From: Carrillo, Abiel X.
Sent: Friday, December 30, 2016 3:51 PM
To: 'Gilbert Aldaz'; Al-Najjar, Marwa G.
Cc: Chad Weltzin
Subject: RE: Sotogrande Housing

PLANNING DEPARTMENT – Development Review Services

**RE: Sotogrande Housing
 Conceptual Grading and Drainage Plan
 Engineer's Stamp Date 12-6-2016 (File: M15D23H)**

GRADING +
DRAINAGE
NORTH SHEET
CIVD2

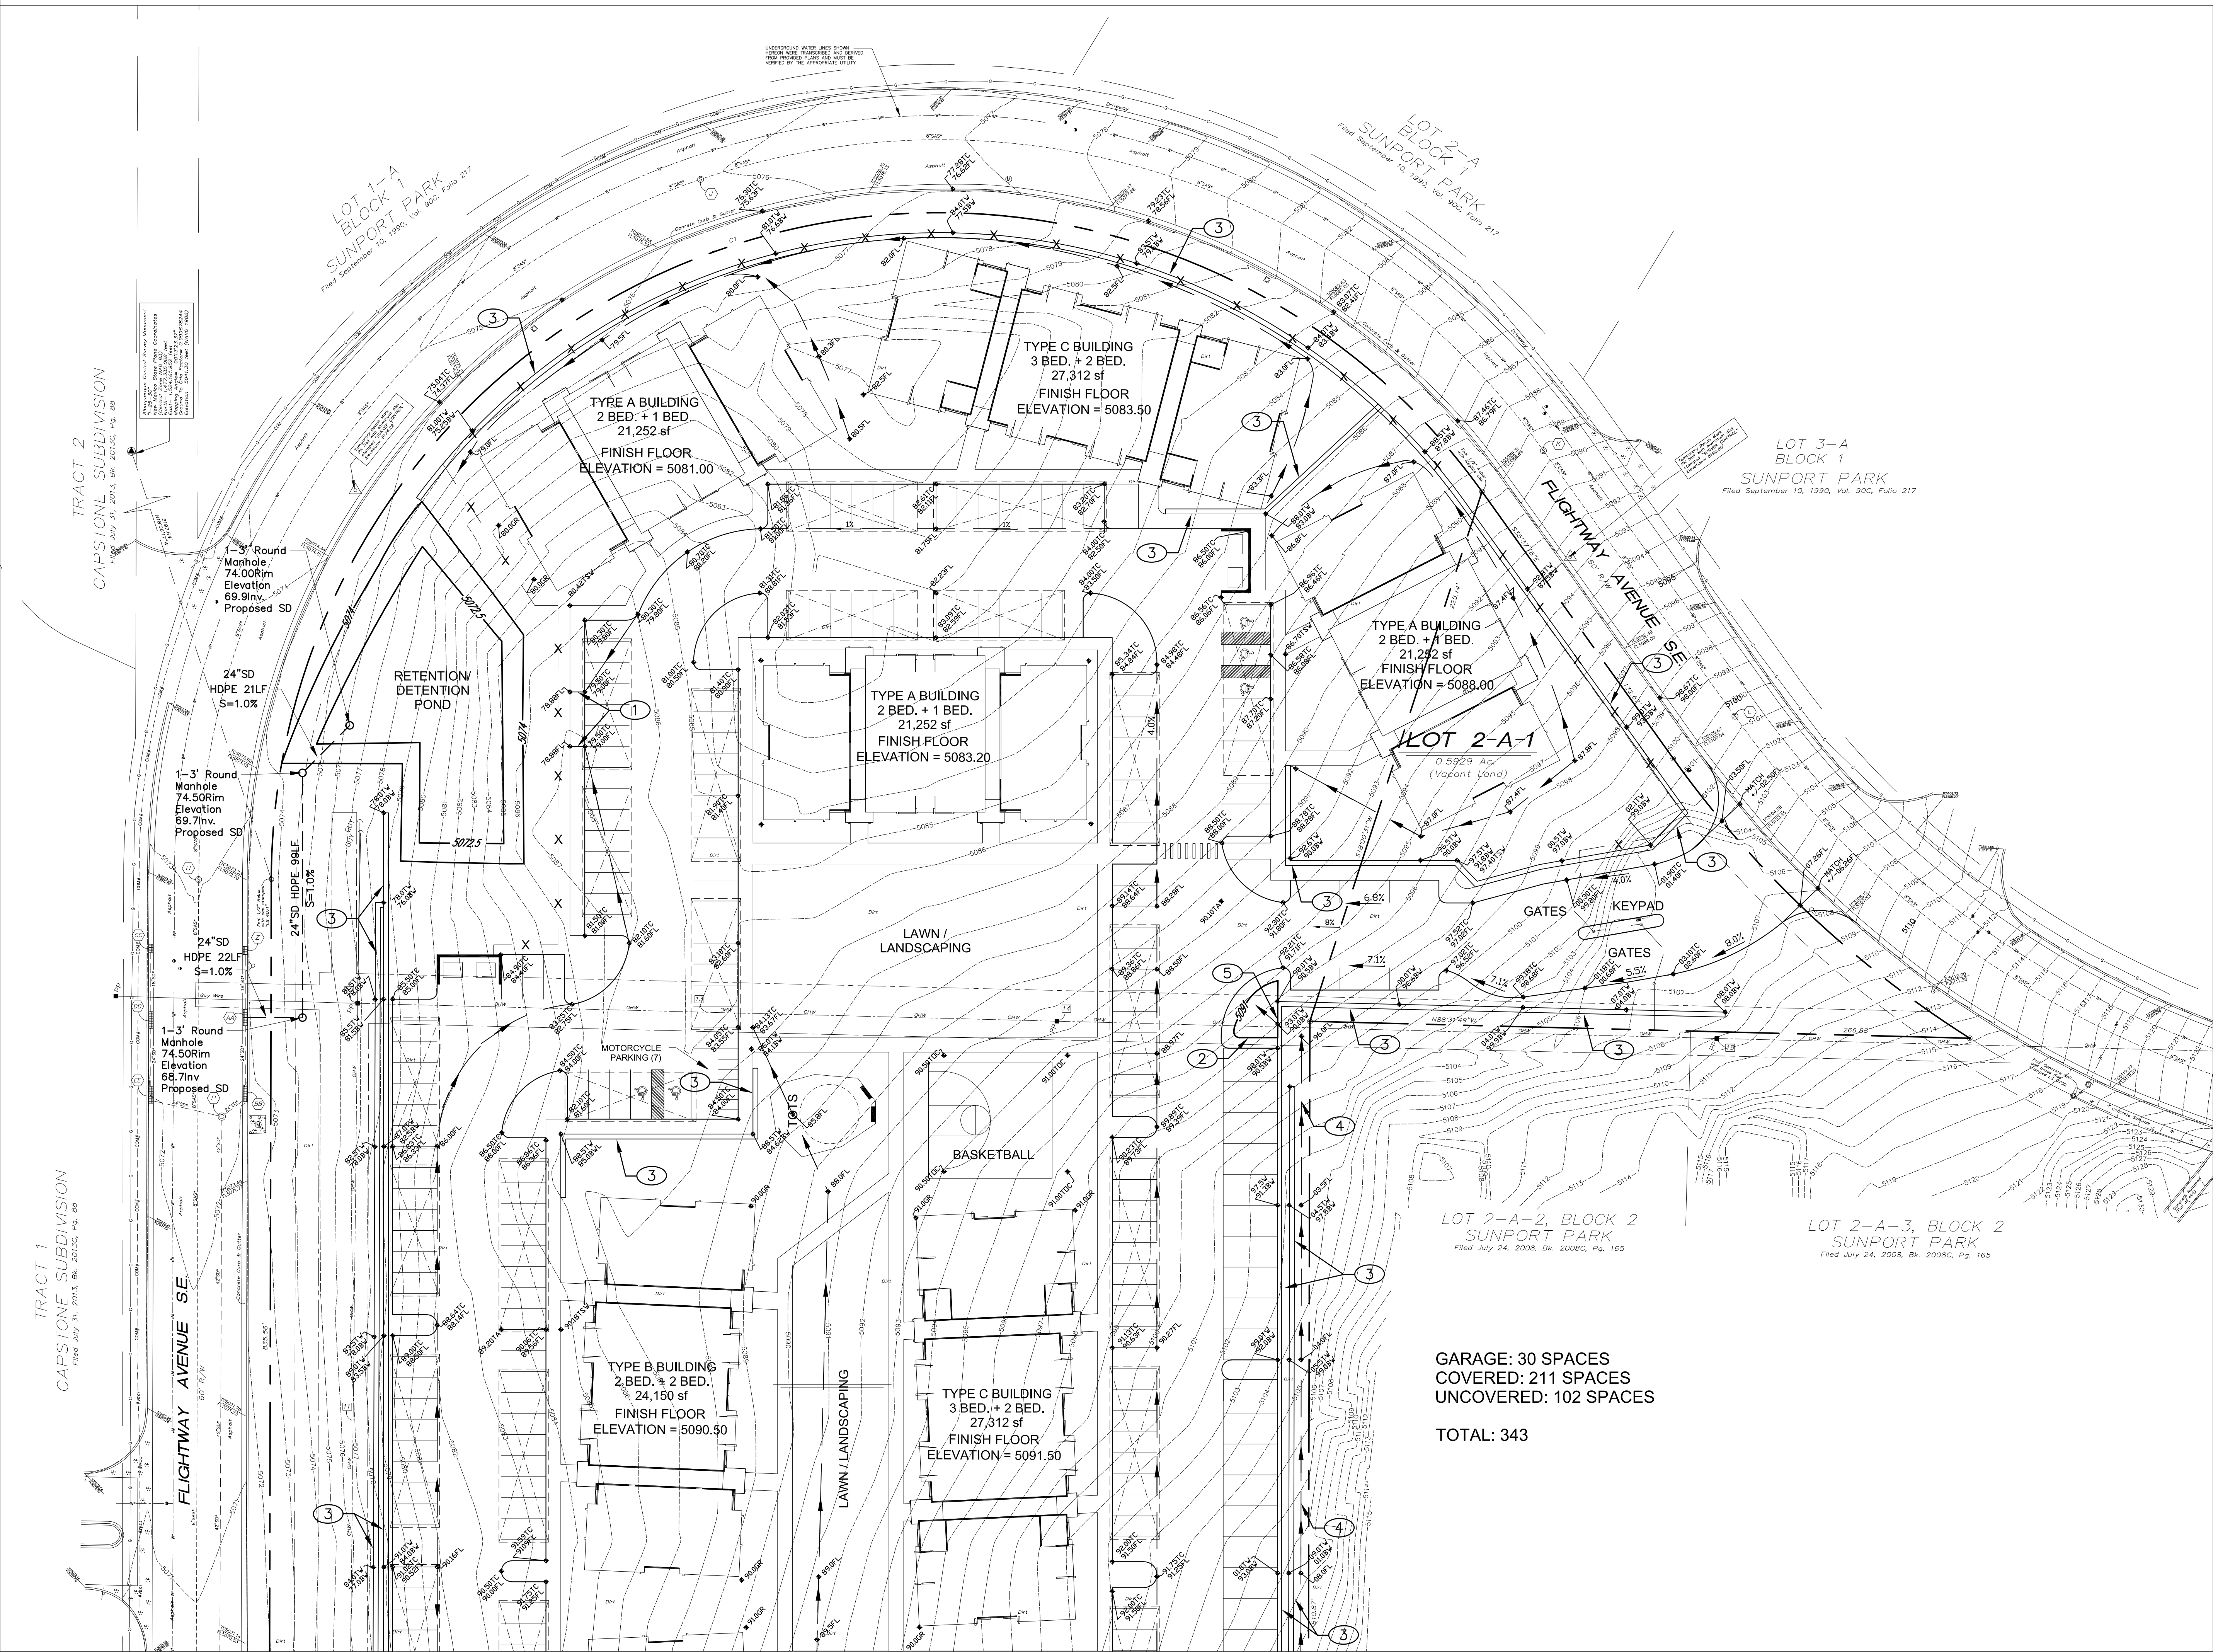
1. Provide Benchmark.
2. The project is large enough that the plan needs to show the design elements developed beyond a conceptual site sketch for Grading Permit Approval. For example, no curb ramps are shown, and it is not clear if the line type used for curbing is the back, or flowline of the curb. Side walk beginning and ends are not defined.

3. Provide a cross section for the offsite flow swales.
4. Provide information and build notes for the driveways (curb, ramps, slops, limits of side walk construction, valley gutter).

5. Should propose an inlet vs a manhole or give detail if it is a specialty manhole (plastic, or other).
6. Show how roofs drain on the plan.
7. The area between back of curb and property line should be depressed or provided erosion control behind curb.

8. Is there an existing cross lot drainage easement on this property to accept flows from the adjacent lot?
9. If possible, the swale that outfalls to the wood ward Rd driveway should pass through a water Quality Pond just prior to the curb cut.

10. Storm Drain connections to the back of a public inlet must be completed through the SO-19 permit process. Please include the standard SO-19 Notes on the plan. The connection will need to reference and comply with Std. DWG 2237.

12. Provide details for the above mentioned concrete channel. Provide cross section of retaining wall segment as well.
13. Include the cross section of retaining walls referenced in keyed note #4.
14. The plan should show how roofs flow will be conveyed across the sidewalks that surround the buildings (sidewalk culvert or piping should be used).

GRADING +
DRAINAGE
SOUTH SHEET

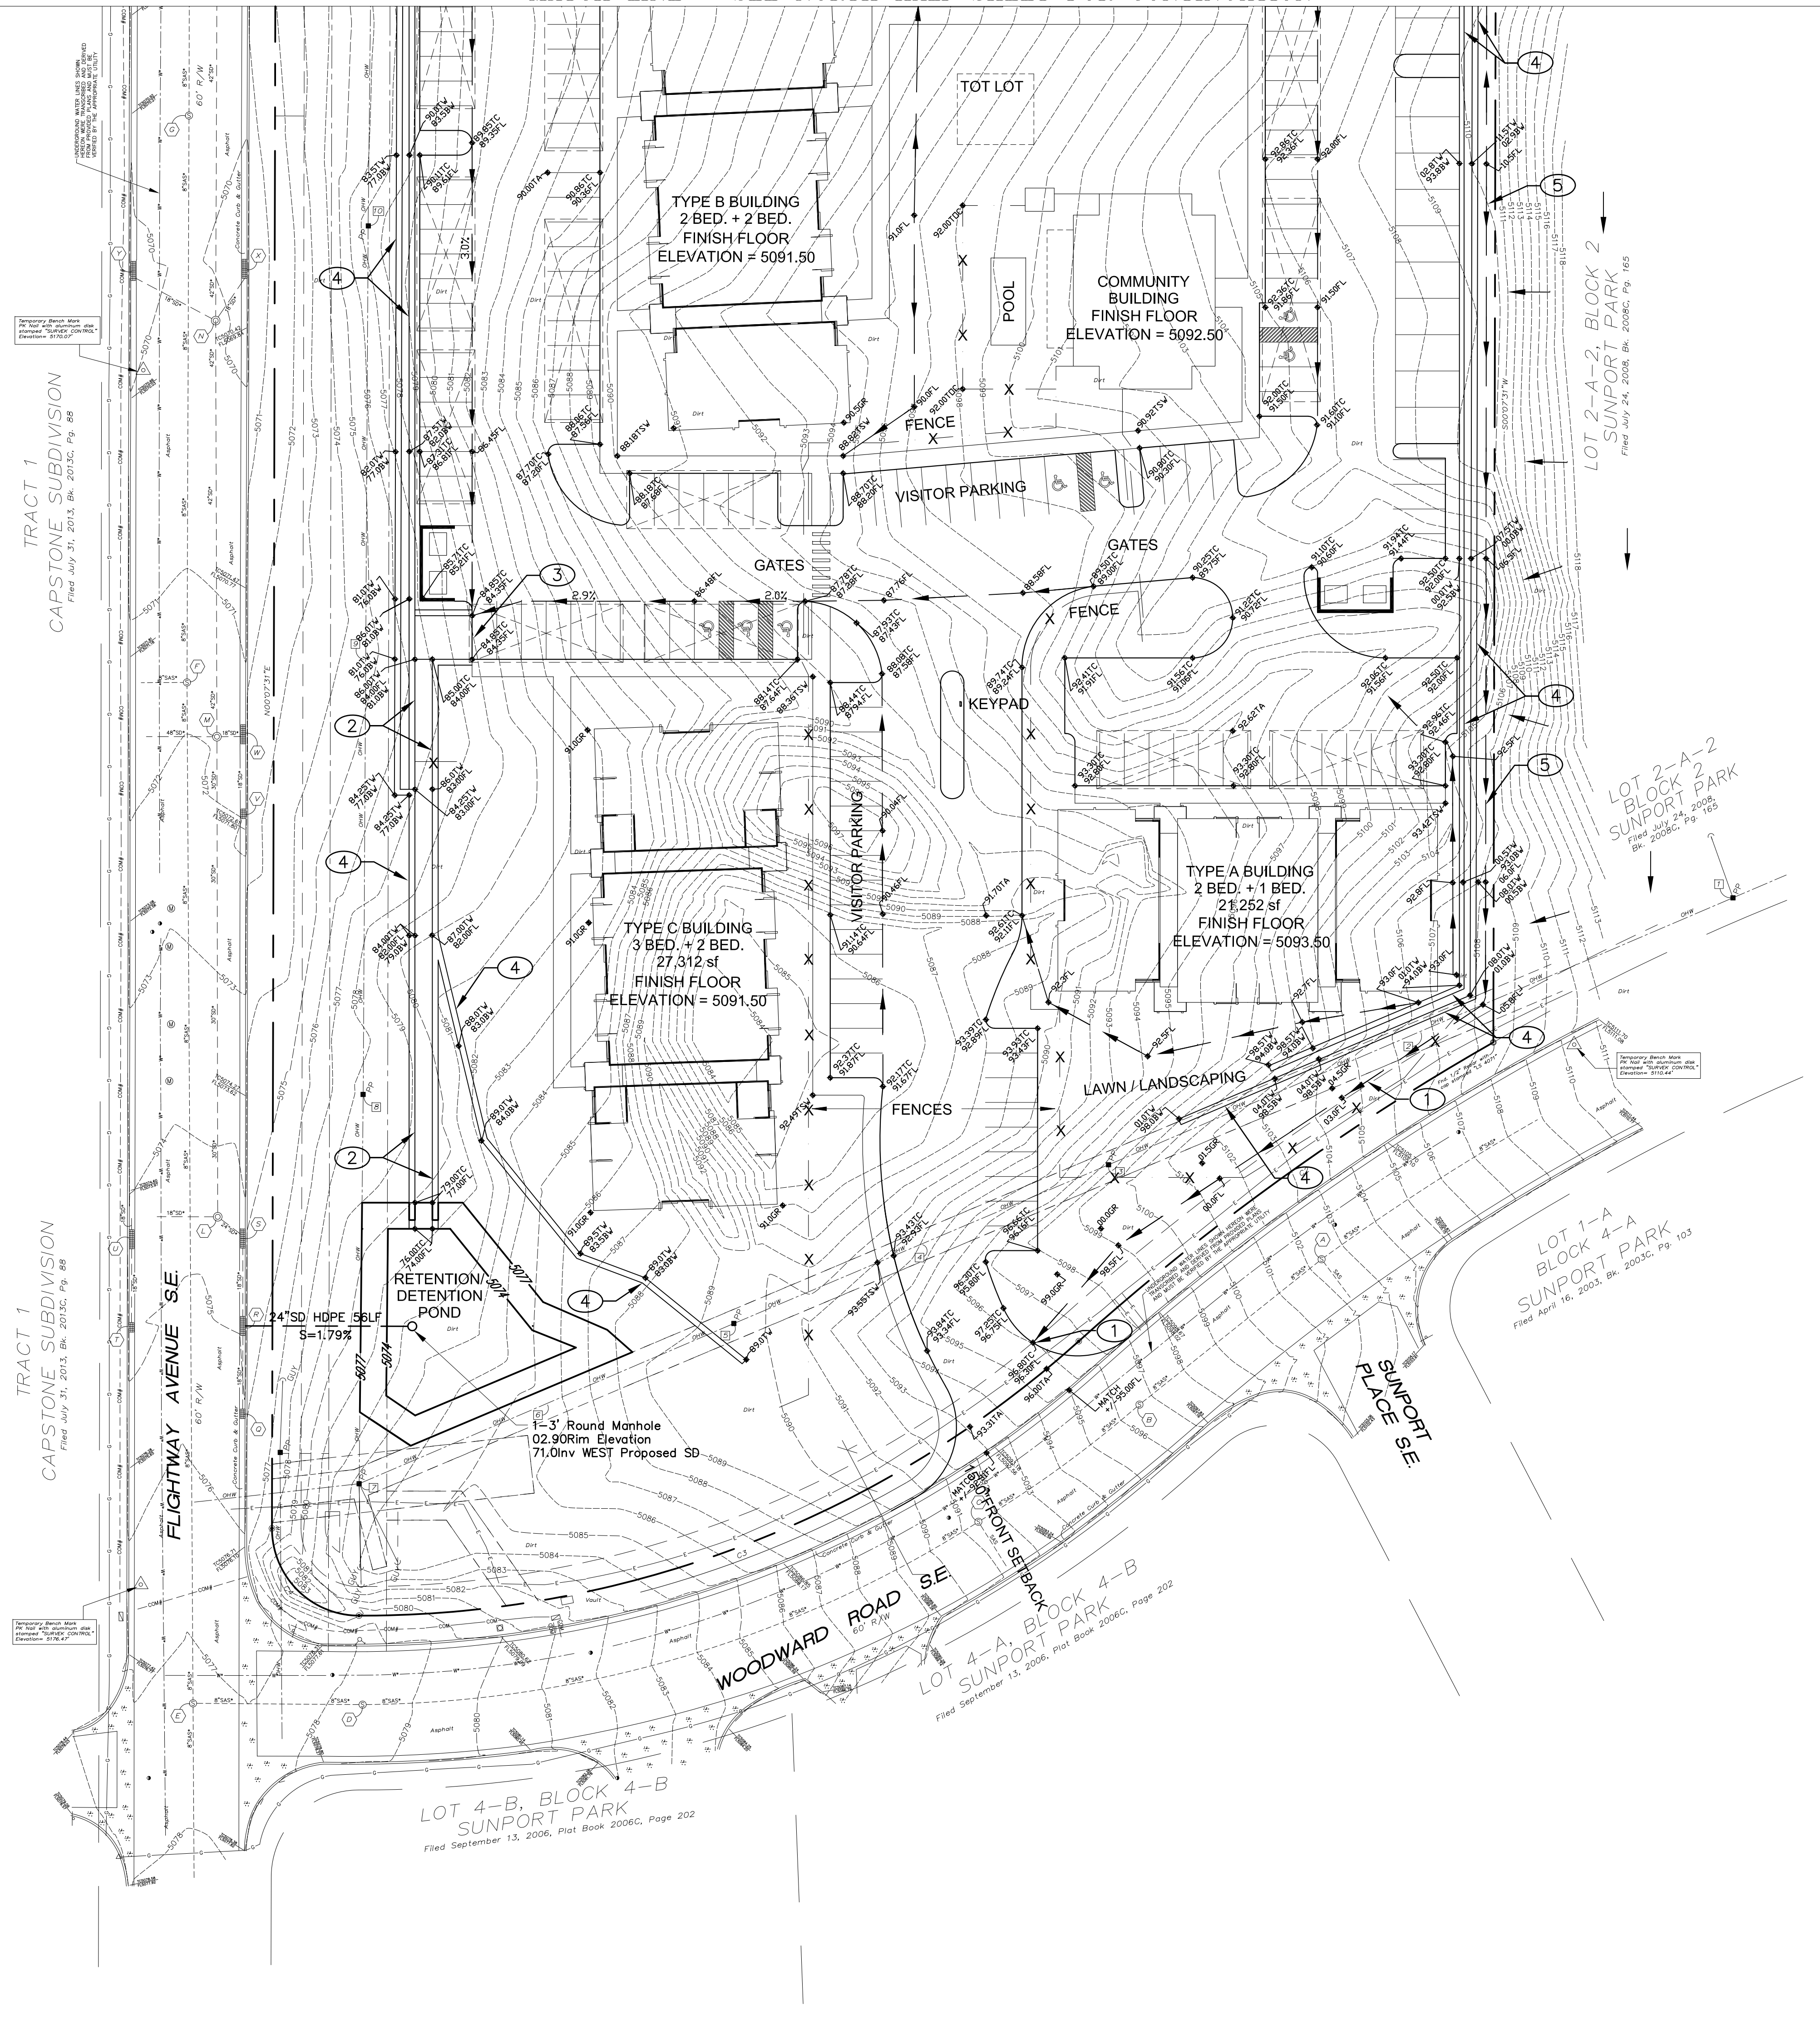
11. Clarify how the concrete channel referenced with keyed note #2 is to be constructed. It is missing information.
